Your Ref: OWPC24232
Our Ref: FP/146/19/HH 03-07-2019
Please ask for:
Amber Willard

Construction of single storey timber frame shed, with tiled pitch roof.
Construction of single storey timber cabin, with felted pitched roof.
Ridgeway House The Ridgway Bognor Regis

Rev A - Dims added to plans from shed / cabin to main building - August 2019

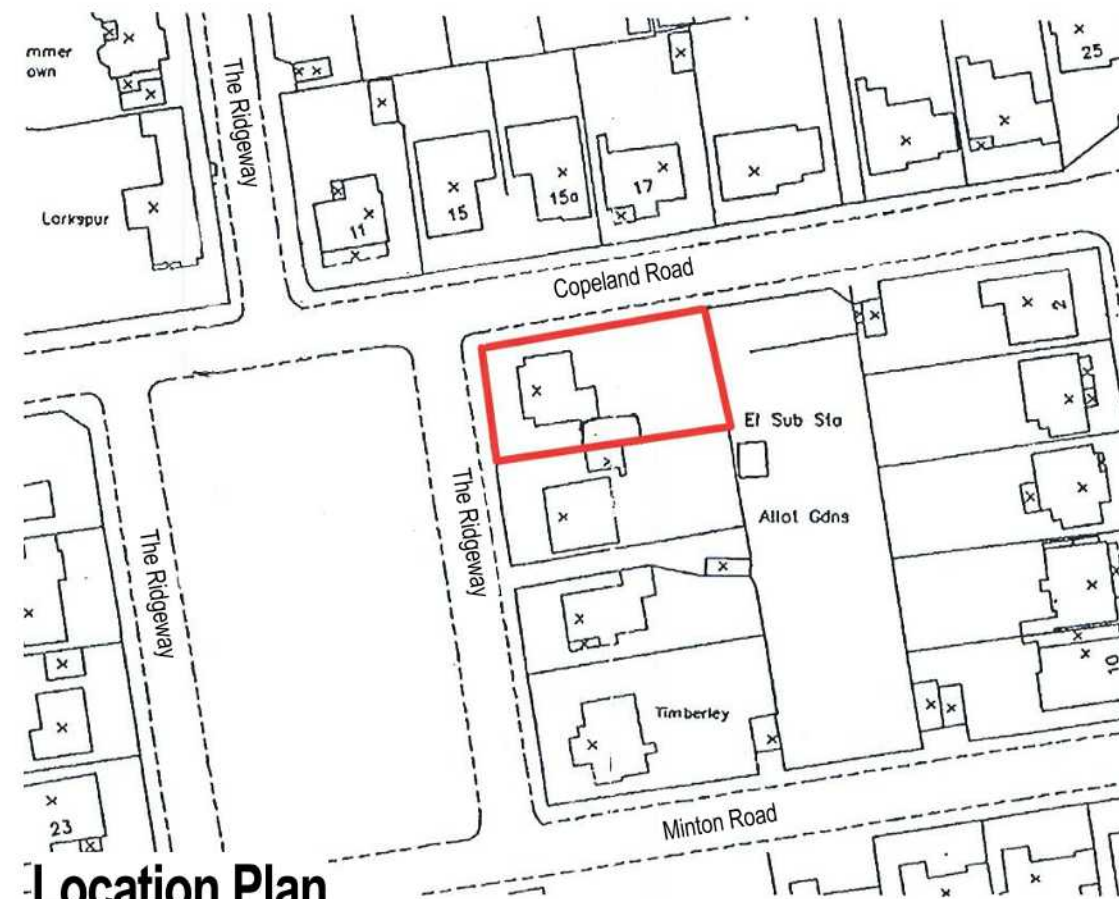
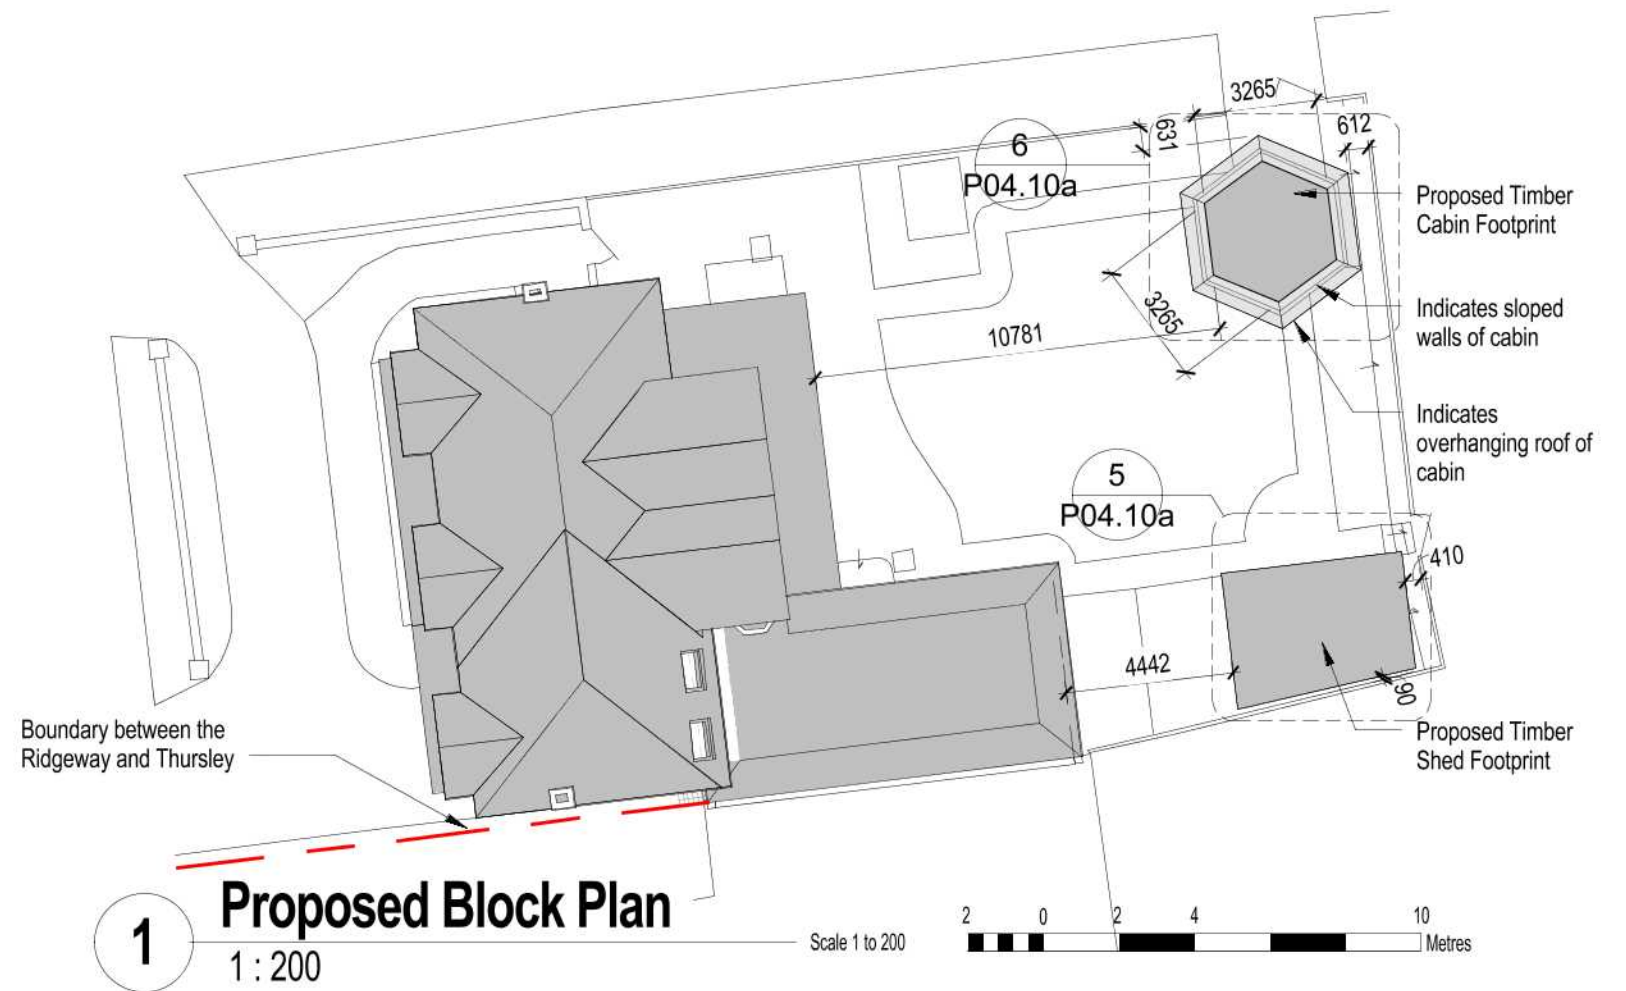
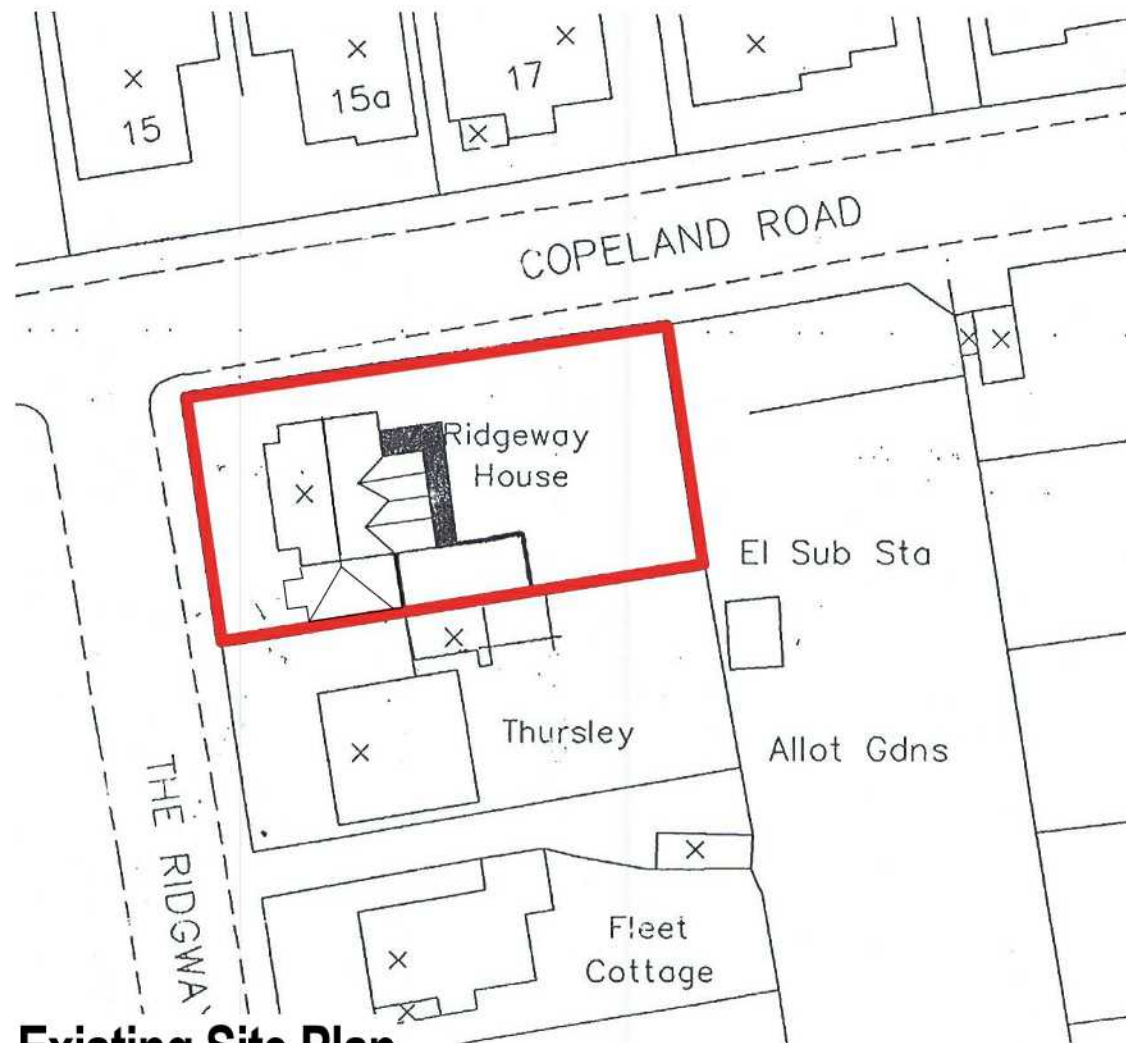
As the Executor of the Estate of S.M. McGee-Russell I fear that the shed built smack up to the fence between 'Thursley' and 'Ridgeway House' will further muddy/encroach/confuse the property line, which began with 'Ridgeway House' incorporating Thursley's external wall into their property in the last years of S.M. McGee-Russell's life (2007/2008). Also, the roof of the shed overhangs the property line fence and will cause significant run-off.
